***Residential Development Stage 1 Phase 1
Royal Rehabilitation Centre, Ryde***

MP10_0189 MOD 3

***Redesign of Main Lobbies, Removal of Entry
Portico & Other Minor Changes.***

Director-General's
Environmental Assessment Report
Section 75W of the
Environmental Planning and Assessment Act 1979

Figure 2: Revised disabled access and changes to ground floor unit 5A. (Source proponent's application)

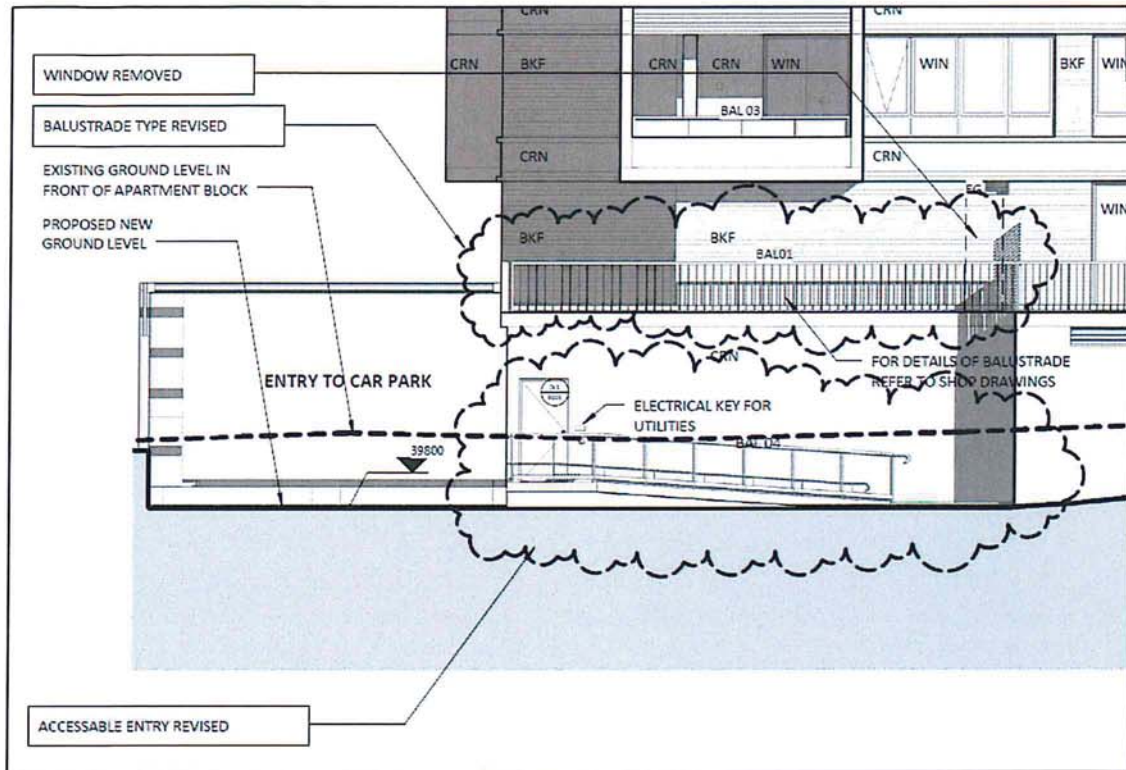
- a reconfiguration of the main entry lobbies to include the apartment's letter boxes;
- provide raked ceilings;
- deleting the entry portico;
- modifications to the disabled entry to the basement to allow for segregated pedestrian and vehicle access to the basement; and
- minor design changes to the roof above unit 28B, a change in the balustrade for unit 5A and the removal of a bathroom window for unit 5A.

The proposed modifications will allow for improved amenity for users of the building. The proposed disabled access increases the accessibility of the basement and allows for persons in a wheelchair to have safe and secure access to the car parking and bin storage area. The access ramp also allows for bicycle users to access the bicycle storage area safely without the need to use the vehicular access ramp or internal vehicle circulation area.

Consequently, no issue is raised with the proposal and the subsequent amendment of Condition A2 to update the plans to reflect the proposed changes.

Figure 3: Removal of Entry Portico and revised Lobby B entry. (Source proponent's application)

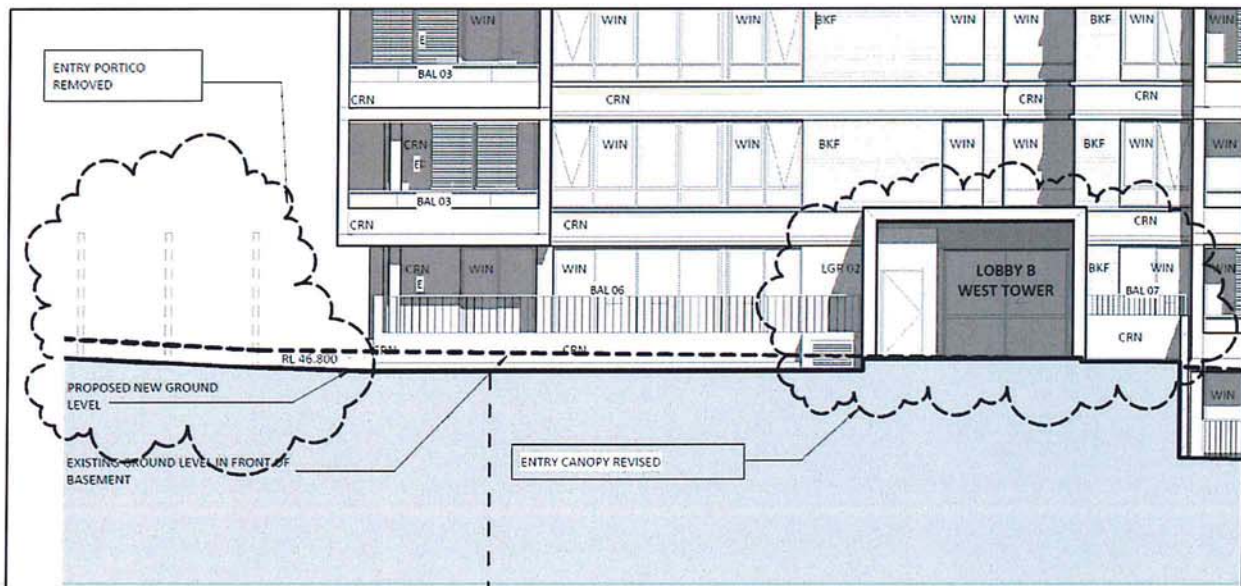
The proposed redesign of the lobbies to include the building's postal boxes allows for a secure and weather proof area allowing residents to access their mail without the need to leave the building. The lobbies are large enough to accommodate the post boxes without impeding access to the building. The raking of the ceiling to increase the flow of smoke presents a improved fire engineering solution to that of the original design.

Figure 5: Removal of architectural features on Level 5. (Source proponent's application)

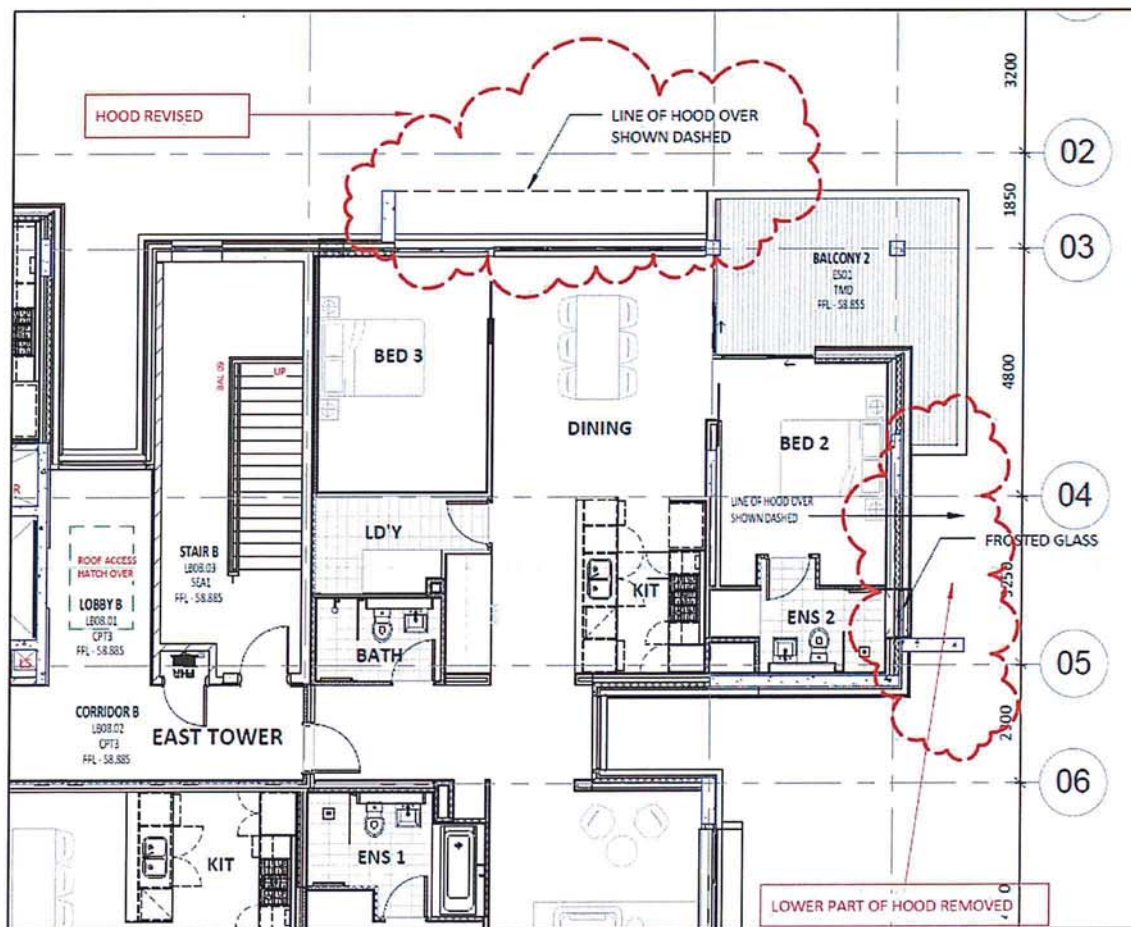
The proposed design changes to the building, including the change of balustrade type on unit 5A, removal of the adjacent planting bed and modification of the roofing sections above unit 28B are minor in nature and are not considered to effect the design quality of the building.
